Geoffrey Sloan Associates

RE: Application for a non-material amendment to the approved applications at Charter Court, Linden Grove, New Malden, KT3 3BL.

I am writing in regards to the application for a non-material amendment to Royal Borough of Kingston upon Thames (RBK) planning approval 17/14632/FUL at Charter Court. The application proposes four changes to the approved scheme along with some general revisions to the elevations which are considered non-material in nature, these consist:

PROPOSED SIDE (NORTH) ELEVATION

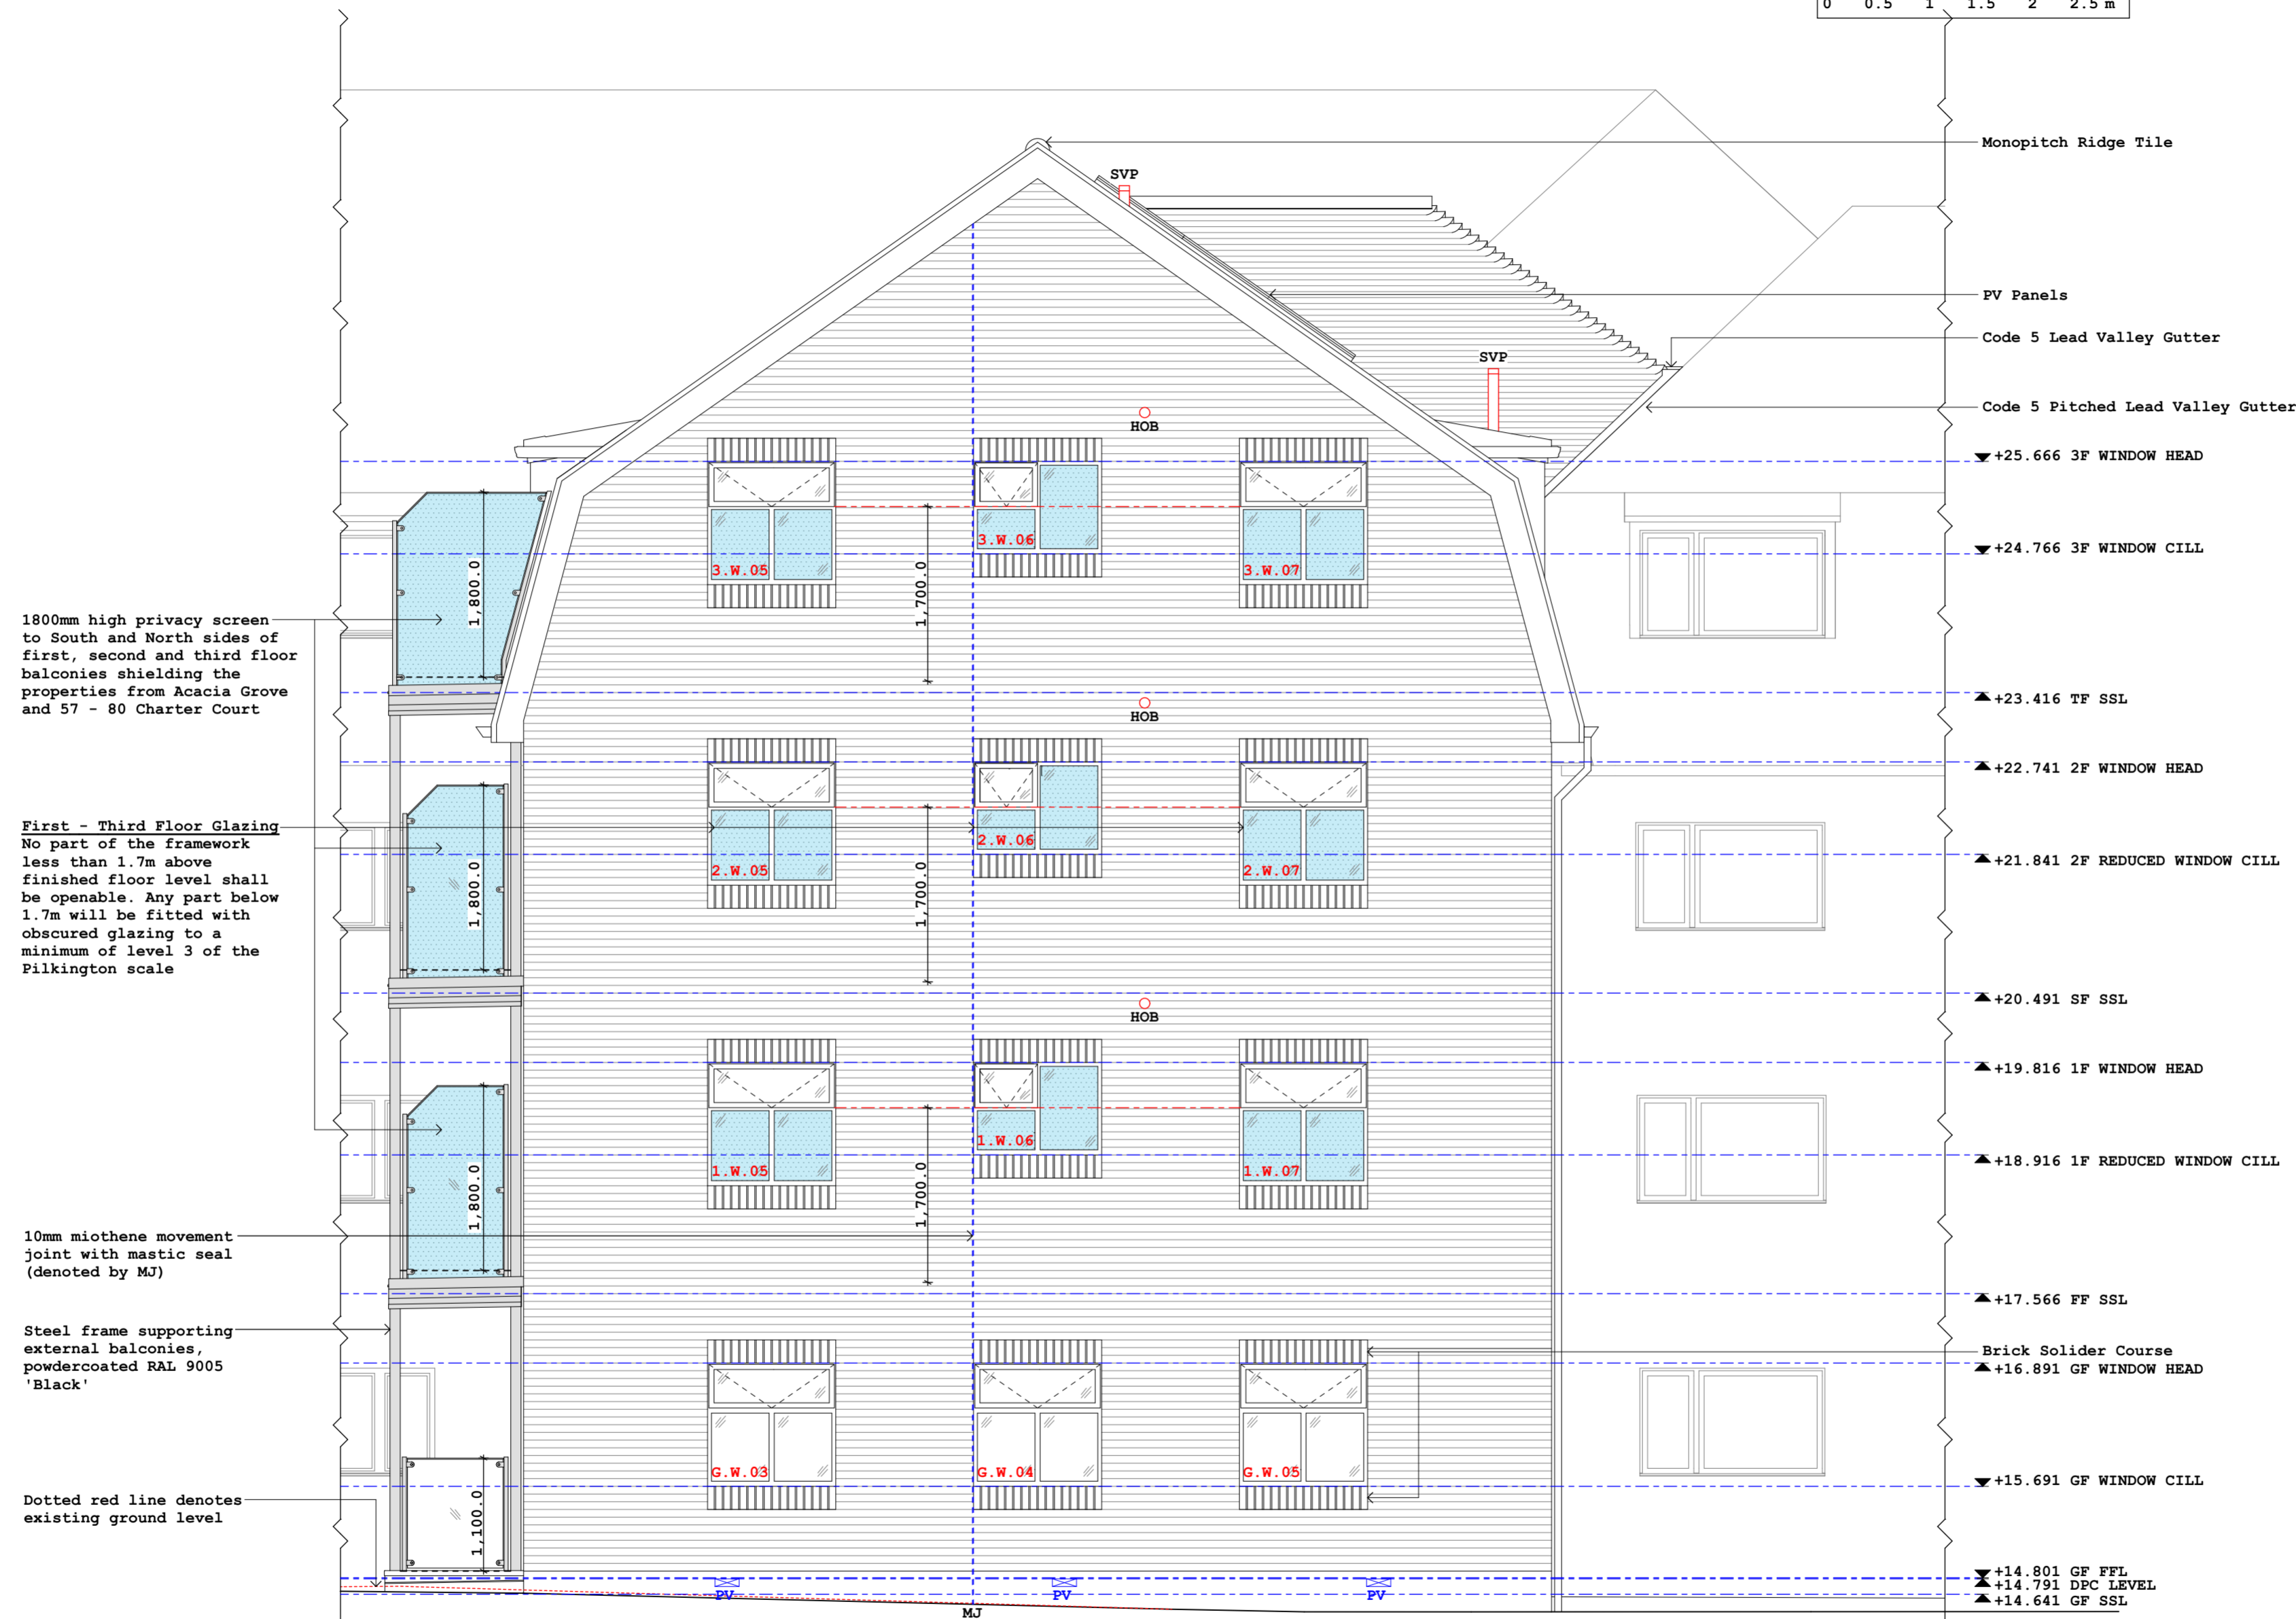
Provision of an open plan kitchen and living room in the ground floor flat required the position of the kitchen and third bedroom to be swapped. This relocates Bedroom 3 to the side (North) elevation of the property and kitchen to the front (East) elevation of the property. Originally the kitchen was provided with a reduced height window to provide a splashback to the worktop. This has been omitted in favour of making the worktop level with the window cill. As such window G.W.04 on the side (North) elevation which now serves Bedroom 3 has been made full height. The window now matches the adjacent windows on both sides.

Relocation of the ground floor kitchen has enabled window G.W.04 to be moved horizontally to line up with the centre of the wall. Windows 1.W.06, 2.W.06 and 3.W.06 have all been aligned to suit.

The proposed balconies have been revised to include slim aluminium fascia panels which provide an aesthetic improvement to the elevations. Black painted steel columns supporting the corners of the balconies have also been added. The proposed balustrading has been revised to suit these additional columns.

- A lead flashing has been added to the mansard change of pitch to provide suitable weathering.
- The provision of post boxes has been amended in the porch area.
- 4no electric meters have been built into the porch wall.
- Additional guttering has been provided to the Side (South) Elevation serving the porch roof.
- Subfloor vents, SVP stacks, boiler flues and extractor outlets have been added as necessary.
